Our Ref: AL/98/17/HH
Your Ref:

Town & Country Planning Act 1990 (as amended)
Town & country Planning (Development Management Procedure) (England) Order 2015
Application for Planning Permission for Works or Extension to a Dwelling

Development Single storey pitched roof extension at rear and side
Location 1 Manser Villas Westergate Street Westergate Aldingbourne

Proposed Roof Plan

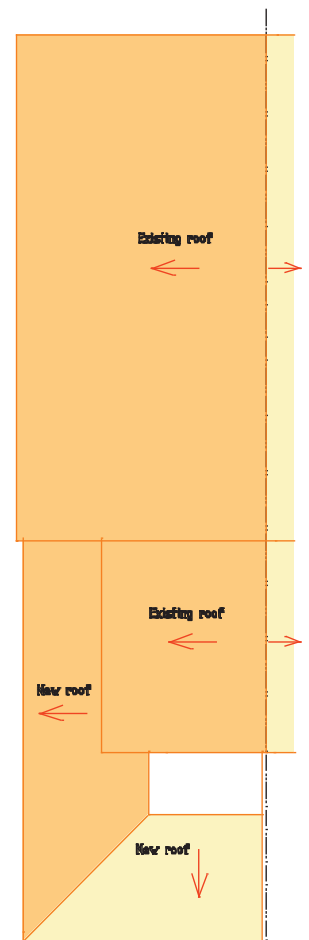
Roof Plans - Pitched roof

Please submit 1 electronic or 3 paper copies of existing and proposed roof plans. Please refer to the National Validation Requirements for further details.
